Rezoning Petition Review

Date of Review: February 22, 2021 (***Revised March 22, 2021***)

Rezoning Petition #: 21-015

Location of Property: Approximately 2.56 acres located at the intersection of West Blvd and Holabird Ln, east of Billy Graham Pkwy and west of Old Steele Creek.

**SKETCH PLAN PRIVATE ALLEY OPTION**

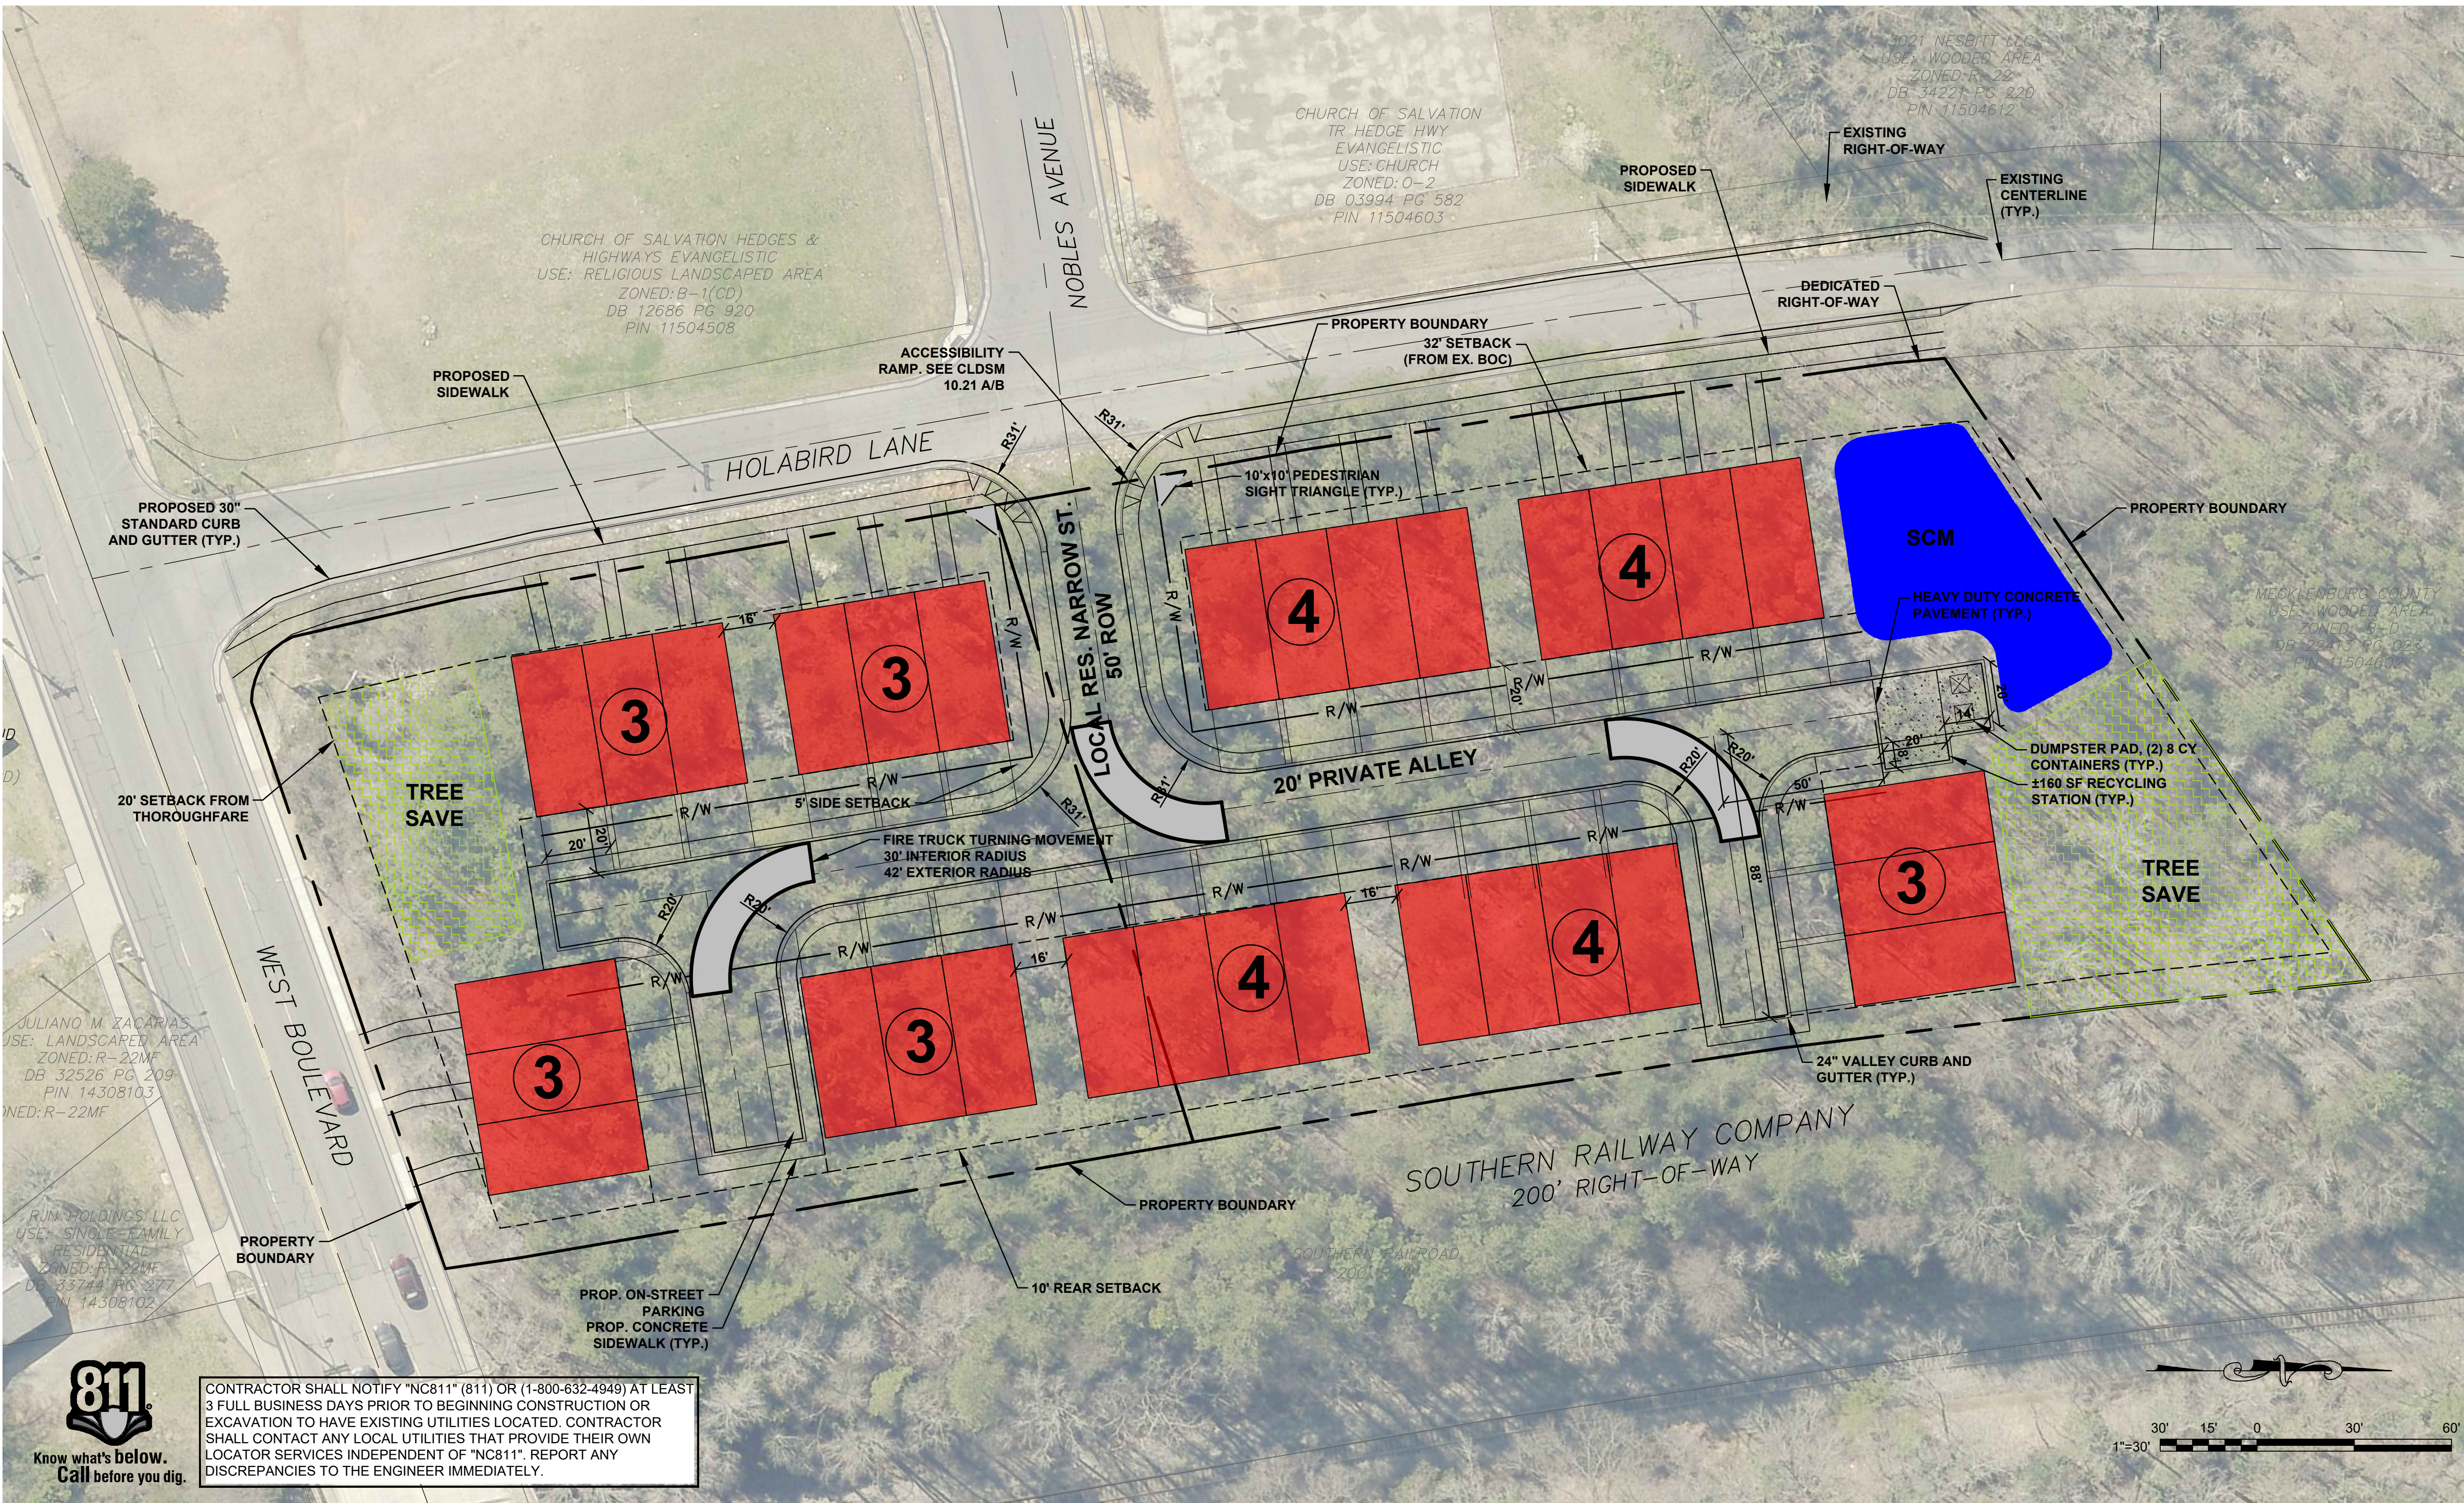
Recommendations Concerning Storm Water: The proposed rezoning plan sheet indicates a proposed location for storm water management. Please include the following notes on the plan sheet under "Environmental Features": *The location, size, and type of storm water management systems depicted on the Rezoning Plan are subject to review and approval as part of the full development plan submittal and are not implicitly approved with this rezoning. Adjustments may be necessary in order to accommodate actual storm water treatment requirements and natural site discharge points.*

Due to revisions (3/22/21): No additional recommendations are needed at this time.
